**Response to Planning application from Hertfordshire County Council (T and CP GDP Order 2015)**

District ref: 6/2021/1380/FULL  
HCC ref: WH/7063/2021  
HCC received: 11 May 2021  
Area manager: Matthew Armstrong  
Case officer: Samuel Tearle

12 SOUTHFIELD WELWYN GARDEN CITY AL7 4ST

Change of use to plant hire (retrospective)

ADDRESS	12 Southfield Little Burrow Welwyn Garden City AL7 4ST
SCALE	1 : 200 /A3
DATE	April 2021
DRAWING NO	SFD/03

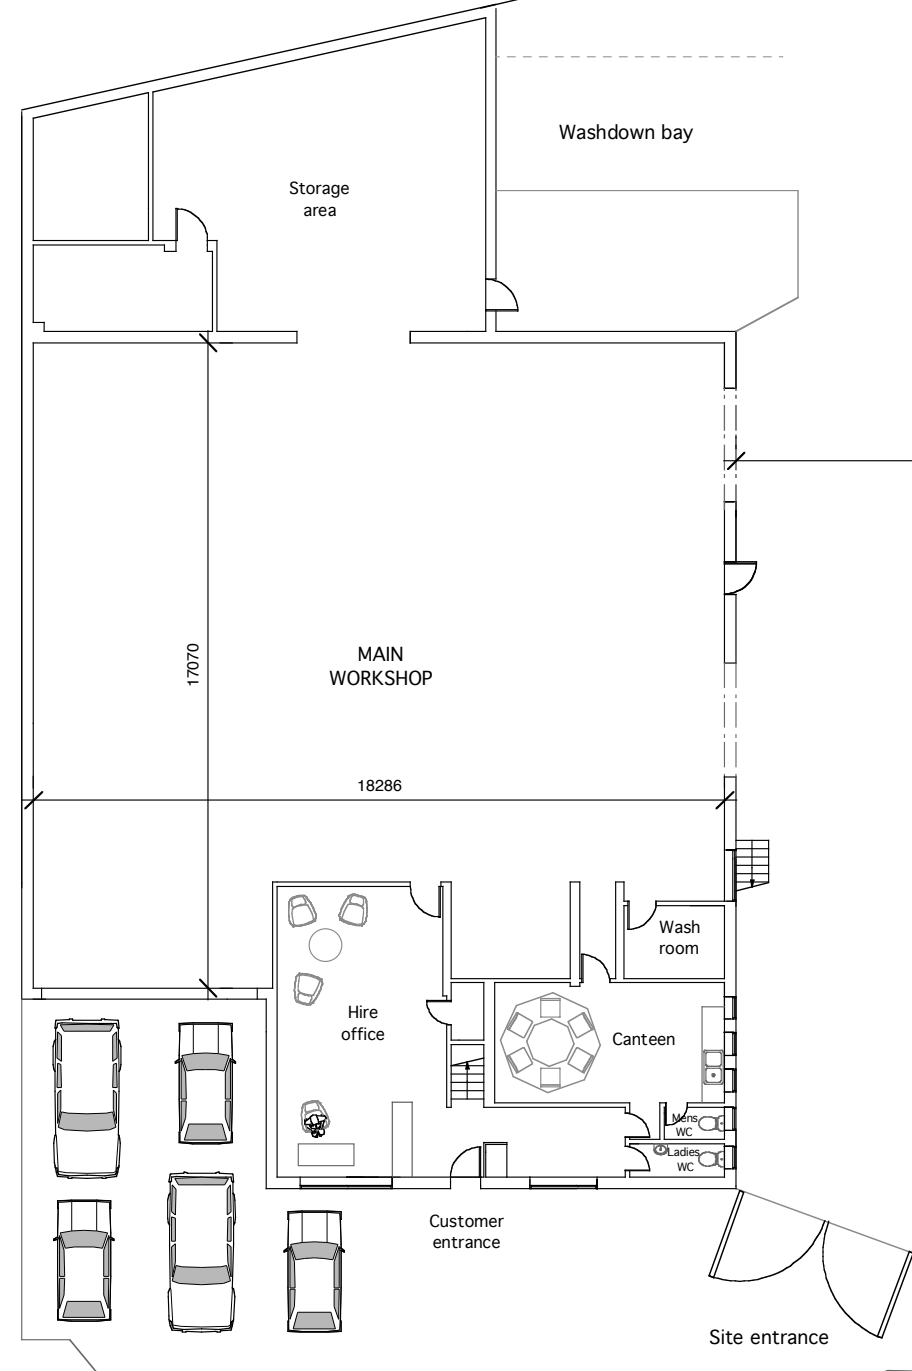
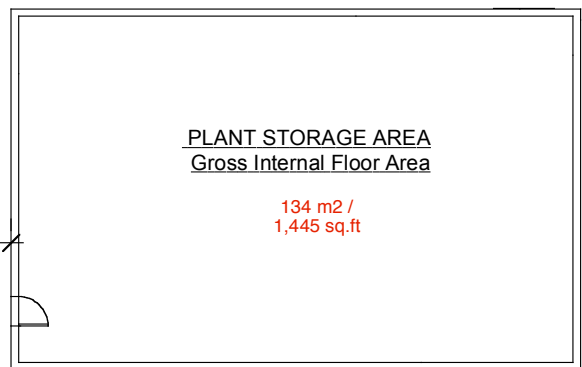
There is also a concern that the details of formal on-site car parking arrangements have not been provided or shown on a plan. Therefore, the turning area of vehicles in the yard may be blocked by informal parking.

The applicant has provided no details of the number of on-site car parking spaces, nor details of cycle parking provision.

Without details of the number of formal car parking spaces, there is a risk the current site adds to the existing footway parking issue. Details of EV charging spaces must be provided.

- Evidence of the 'Current' trip generation of the site on a typical weekday [this must include a breakdown of the type of vehicles attracted to the site, number of staff etc];
- Details and dimensions of the types of vehicle, including low loaders and associated swept paths /turning process;
- Details of formal on-site car and cycle parking provision shown on a plan;
- Review of personal injury collisions on the local highway network over the most recently available five years of data.
